Application for a non-material amendment following a grant of planning permission.

Single storey side extension. Single storey rear extension. Conversion of flat roof to pitched roof above kitchen to create habitable roofspace. Conversion of roofspace to habitable use to include a rear dormer. This application affects the character and appearance of the Arundel Conservation Area. The application affects the setting of a Listed Building.

Reference number:	AB/42/19/HH
-------------------	-------------

Additional conservation style rooflight to be inserted into Western Roof slope over enlarged landing

DATE: APRIL 2019
SCALE: 1:100 @ A3
JOB No. 1069
DRWG No. 104 Rev. A

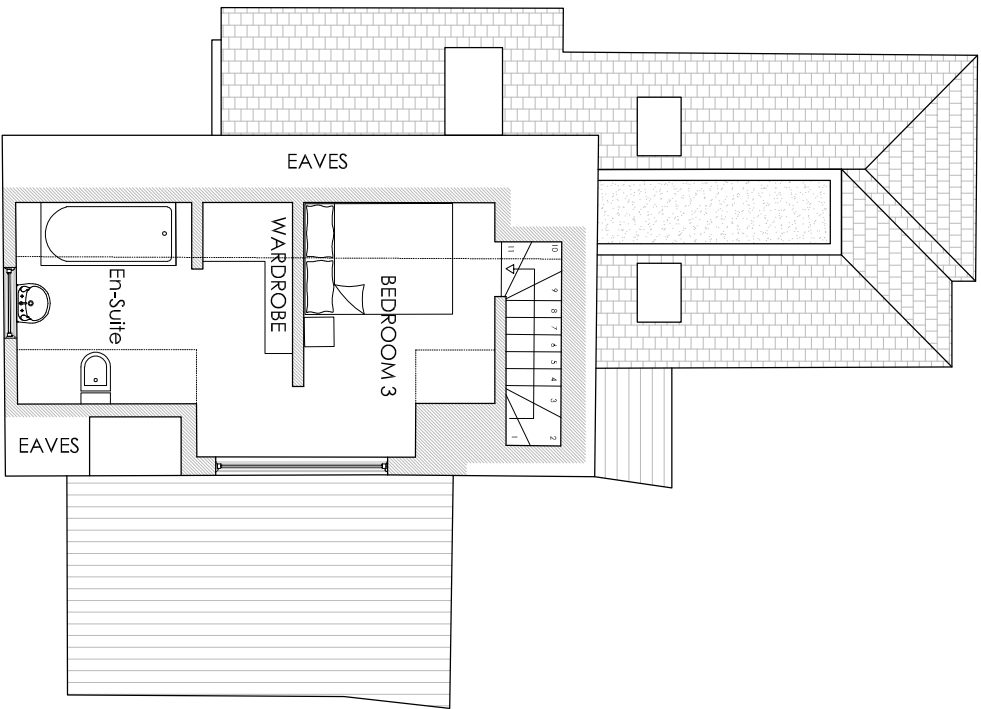
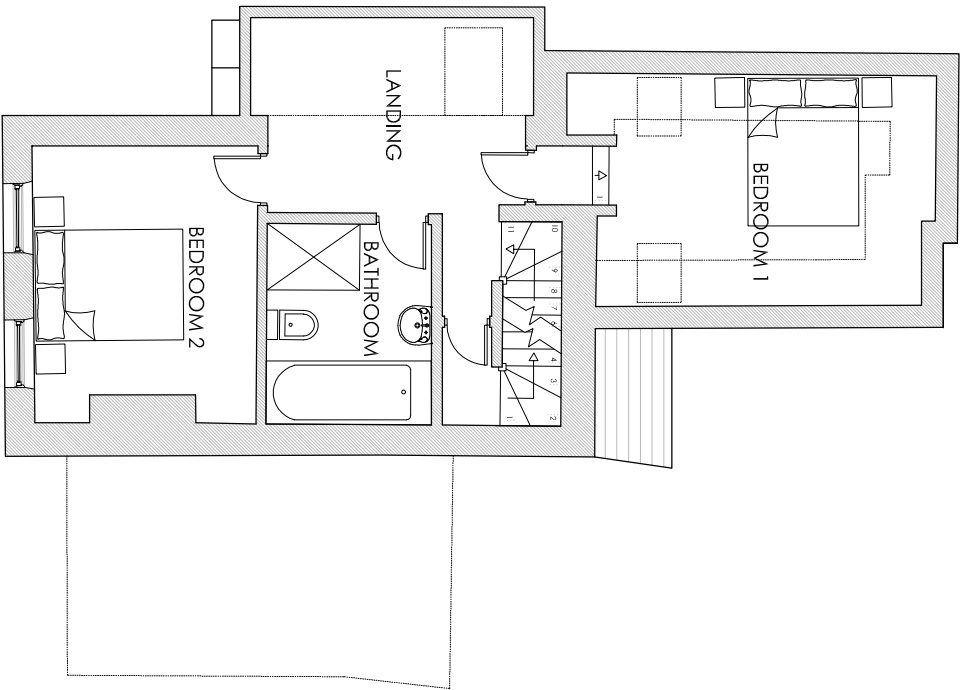
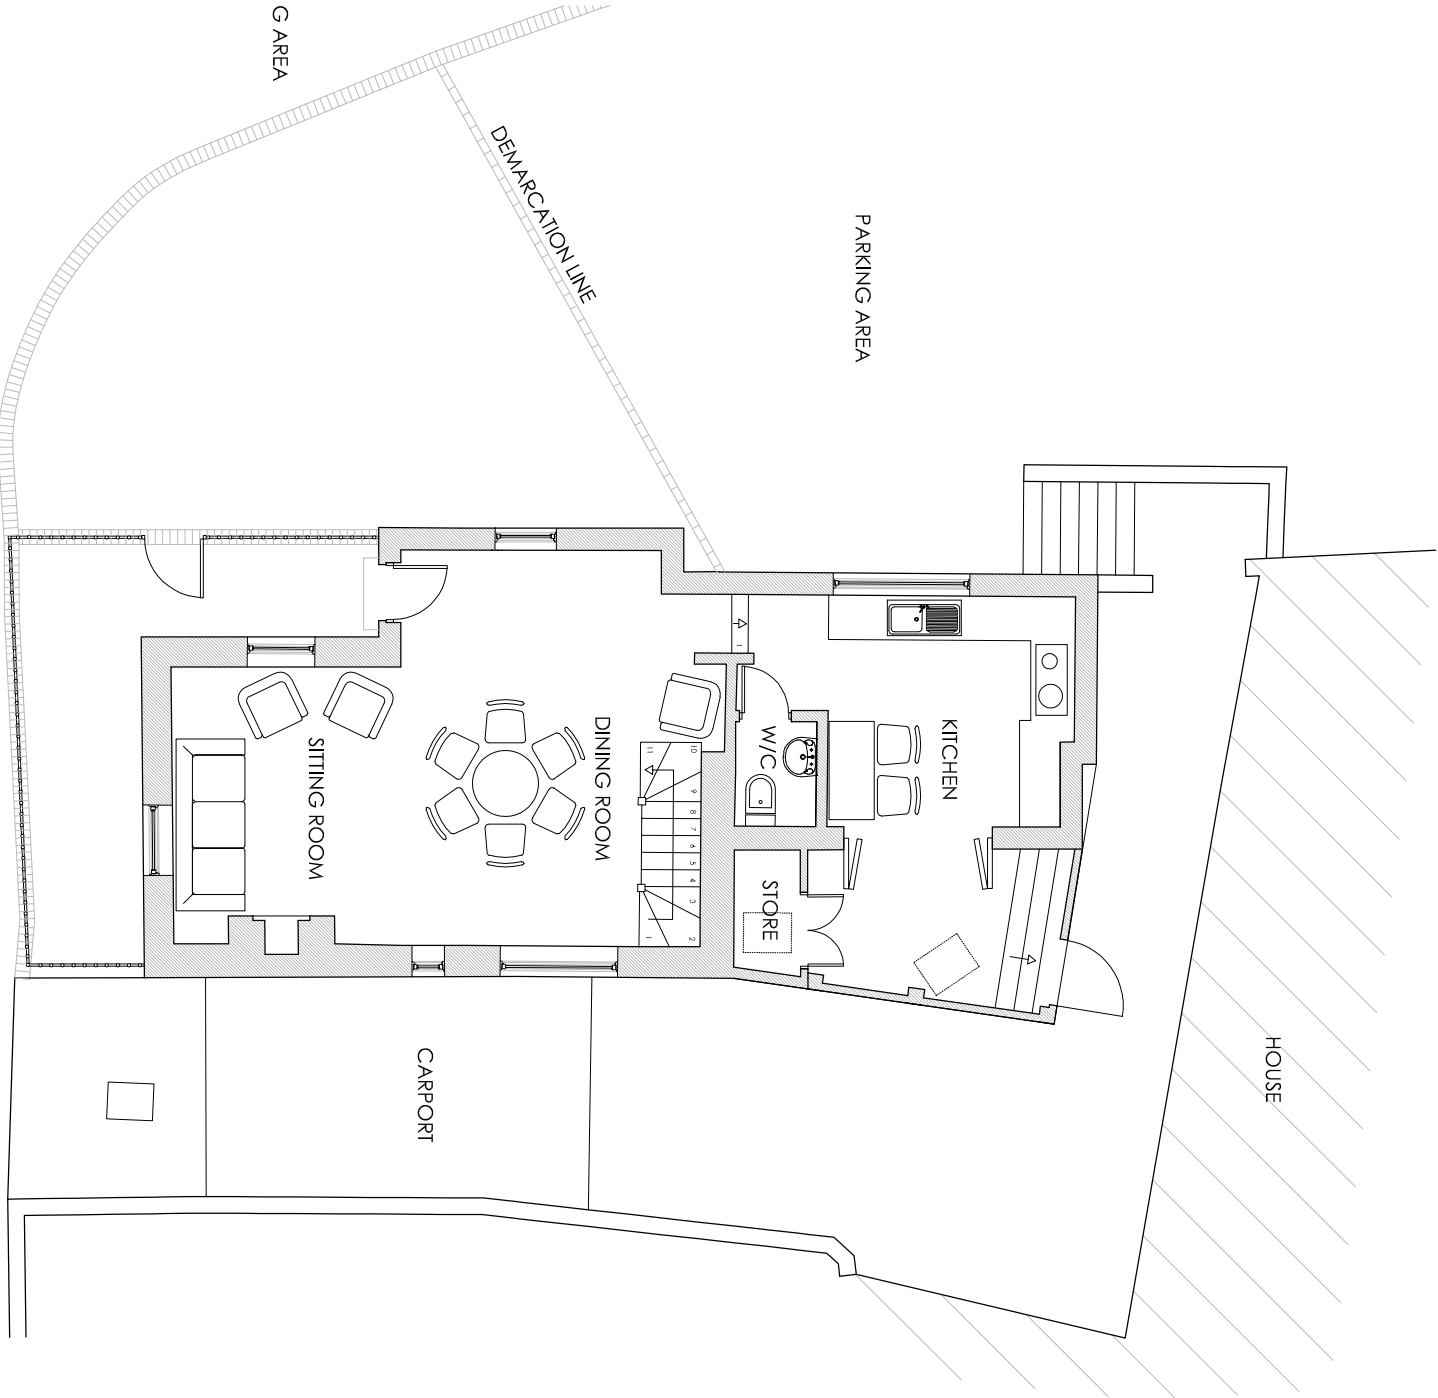
1069_104_Rev.A_Proposed Floor Plans
1069_105_Rev.A_Proposed Elevations
1069_106_Rev.A_Proposed Sections
